**From:** [REDACTED]  
**To:** [Norfolk Boreas](#)  
**Cc:** [REDACTED]  
**Subject:** Deadline 1 - Information as requested by the ExA  
**Date:** 24 November 2019 22:20:19  
**Attachments:** [Hornsea 3.zip](#)  
[Norfolk Vanguard.zip](#)  
[Norfolk Boreas Offshore Wind Farm – Evidence from submissions to Hornsea 3 and Norfolk Vanguard planning enquiries.docx](#)  
[CAWSTON PC – Representations made by residents to Hornsea 3.docx](#)  
[CAWSTON PC – Representations made by residents to Norfolk Vanguard.docx](#)

## NORFOLK BOREAS OFFSHORE WIND FARM – EVIDENCE FROM SUBMISSIONS TO HORNSEA 3 AND NORFOLK VANGUARD PLANNING ENQUIRIES.

Summary of Cawston Parish Council's submissions of evidence to the National Infrastructure Planning Inquiries for the Hornsea 3 and Norfolk Vanguard Wind Farms.

CAWSTON HIGH STREET - INTERVENTION SCHEME  
Scale 1:500

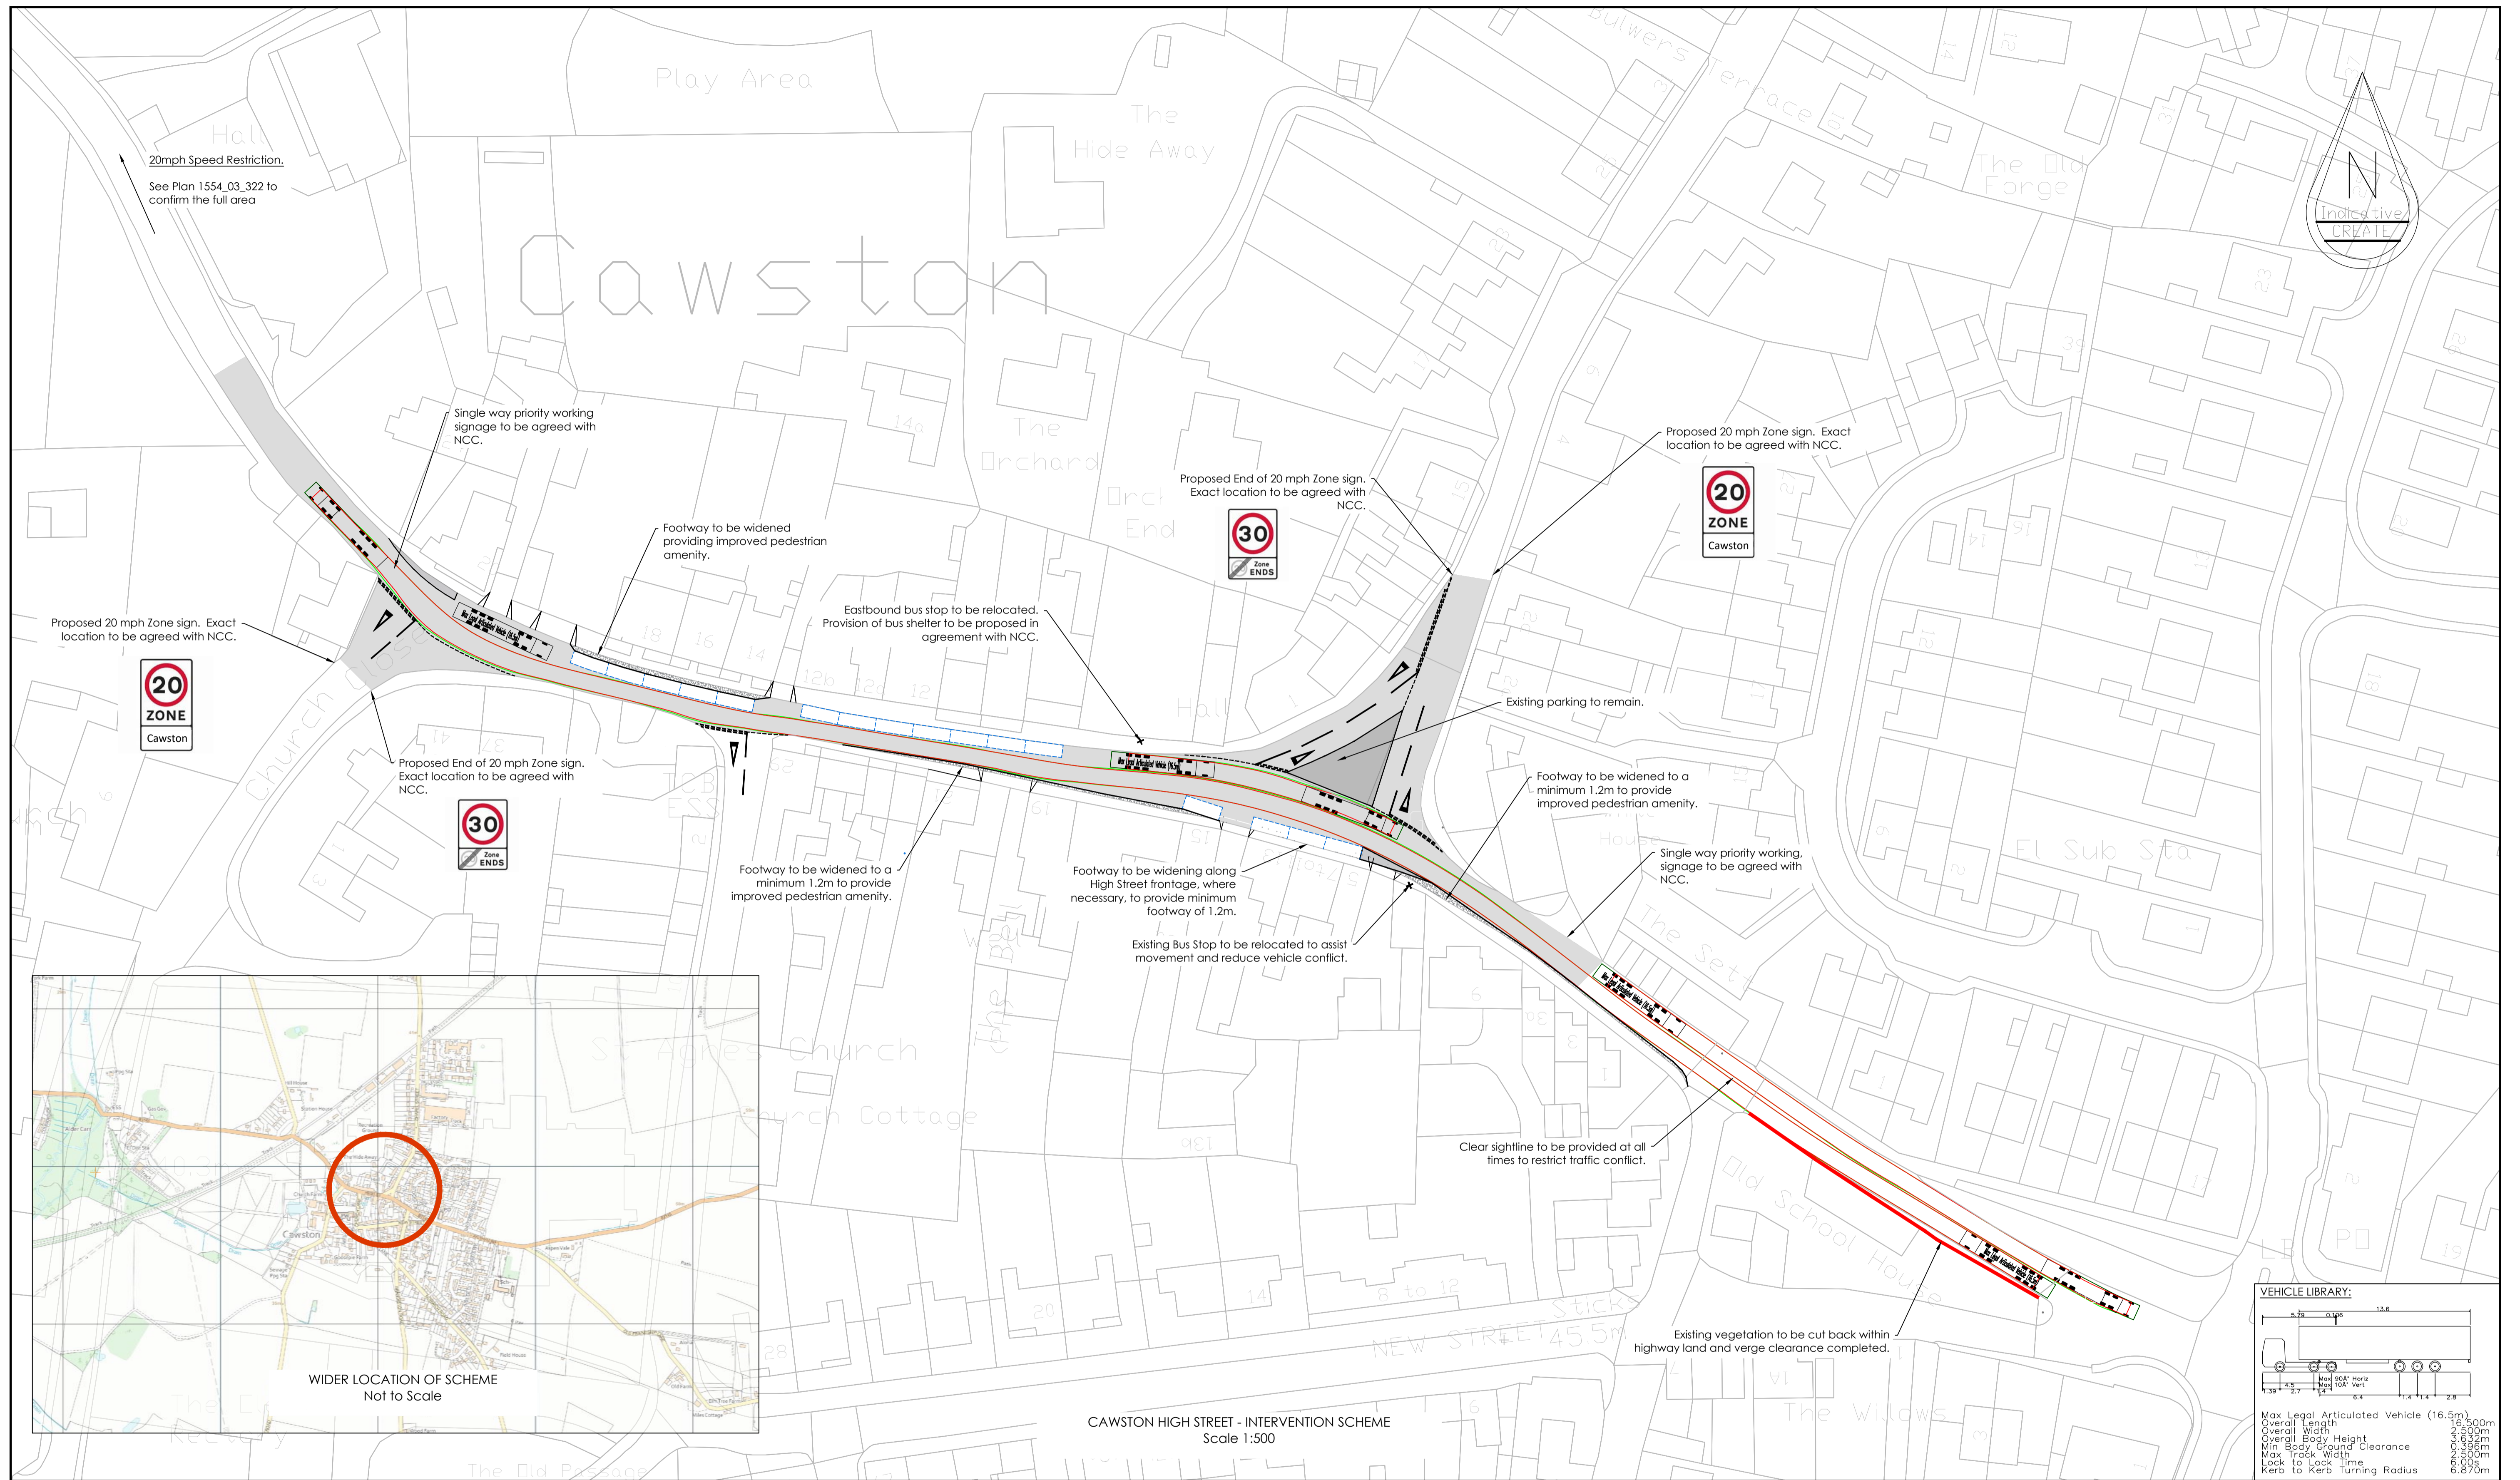
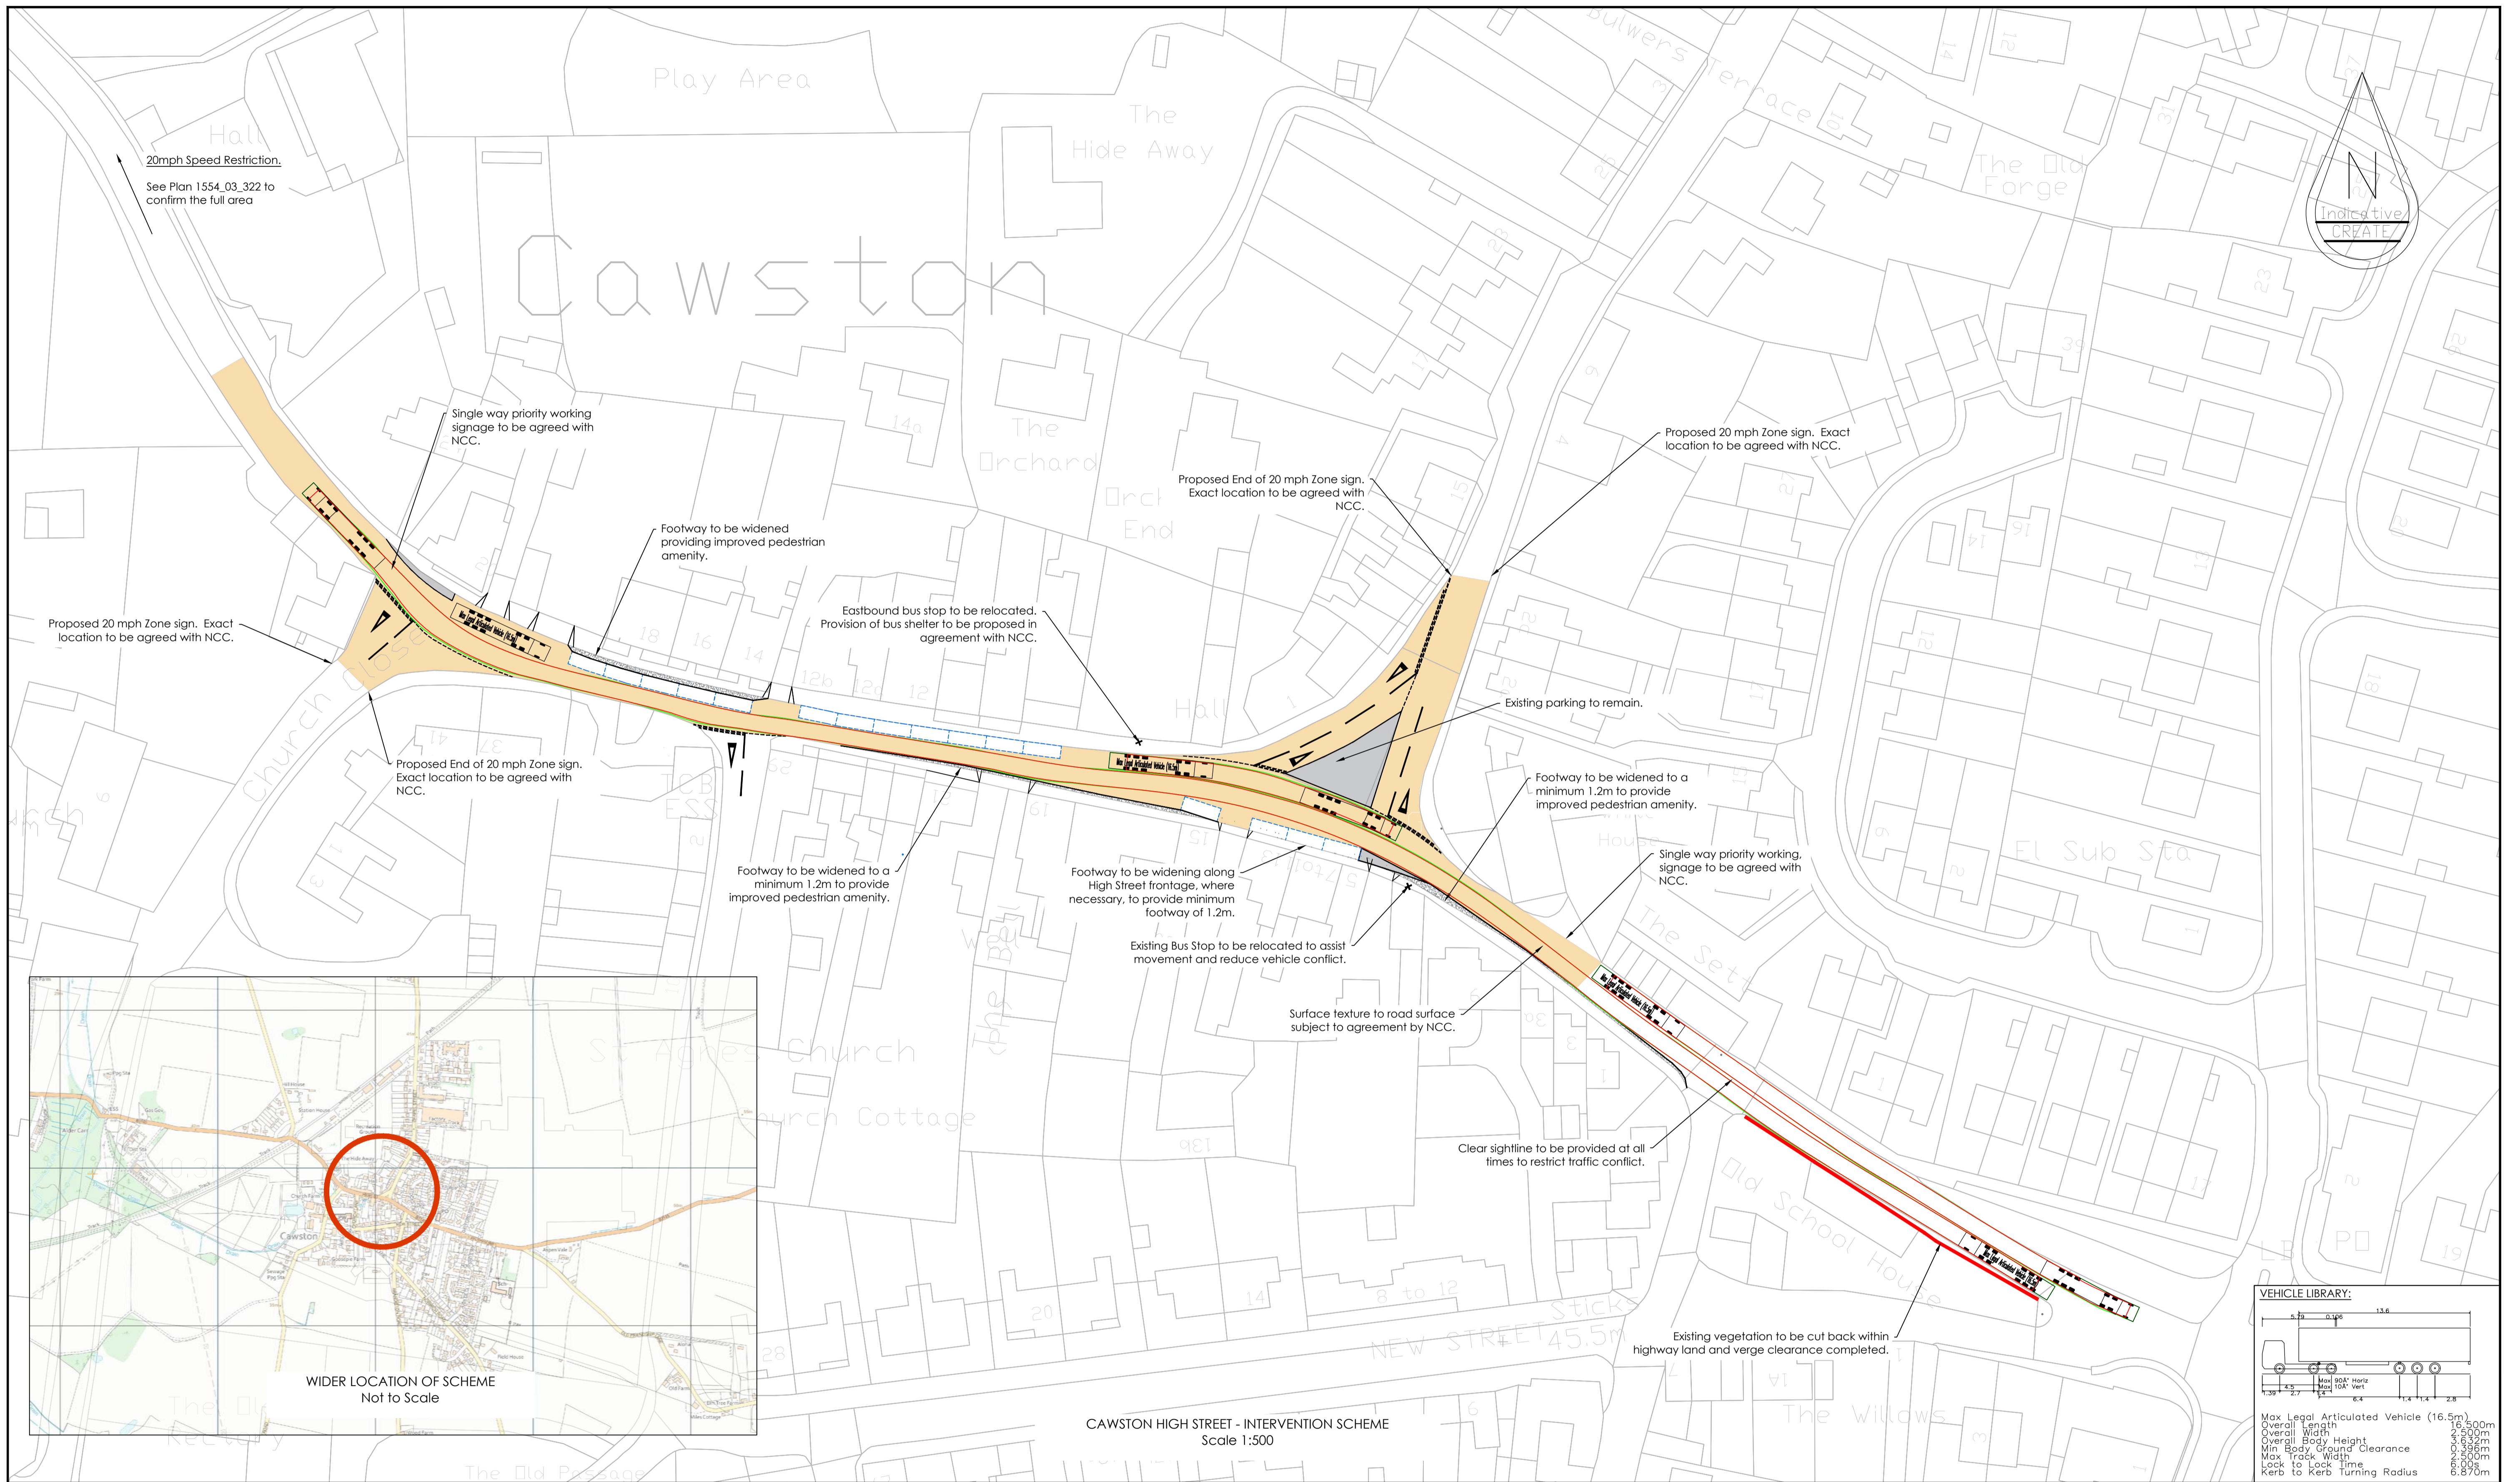
The Hornsea 3 requirement is for 127 daily HGV movements directly through the centre of the village ,plus associated vehicles. The widening of the pavement outside the pub and deli will provide a road that is not wide enough for two-way traffic. If vehicles can't pass further down High Street, because of HGVs in a holding position who knows how far the backlog of traffic would stop. Both directions of traffic then waiting a turn to drive along the High Street.

How will the flow of traffic be managed? I ask this with particular reference to the blind curve where High Street/ Aylsham Road meet, drivers will not be able to see the road or traffic ahead to work out whose turn it is to move. Traffic will also need to join this scenario from Chapel Street, other side roads and numerous driveways. Outside the Old Forge it appears long vehicles will have to drive into the side road to make the bend.

Is this safe? How will that work for resident trying to exit their road?

*5e.) Proposed highway intervention scheme This proposal removes the High Street parking, where will residents now park? How will the one-way flow at a time be managed? The County Councillor referenced previous investigations into limiting parking on this stretch, limits were not put in place so surely the reasons for this and conclusions of those council investigations should be referenced.*

- Market Hill; The proposed remodelling of the area by providing end on parking to the west and limited short term parking outside All Things Nice is not acceptable and will result in a major change to the historic character of the village. In addition businesses which rely on passing trade will be severely affected. In 1263 John de Burgh obtained a charter for a market every Wednesday and a fair on 1st and 2nd October, the proposed remodelling of the Market Hill will make this impractical should the village wish to reintroduce the market.

- The High Street has several listed buildings and by their very nature are likely to be structurally affected by the proposed additional heavy traffic. Off street parking is also extremely limited in this area and the proposal to introduce no parking on the High Street and Chapel Street could well result in cars parking in inappropriate places with the potential to restrict emergency vehicles.
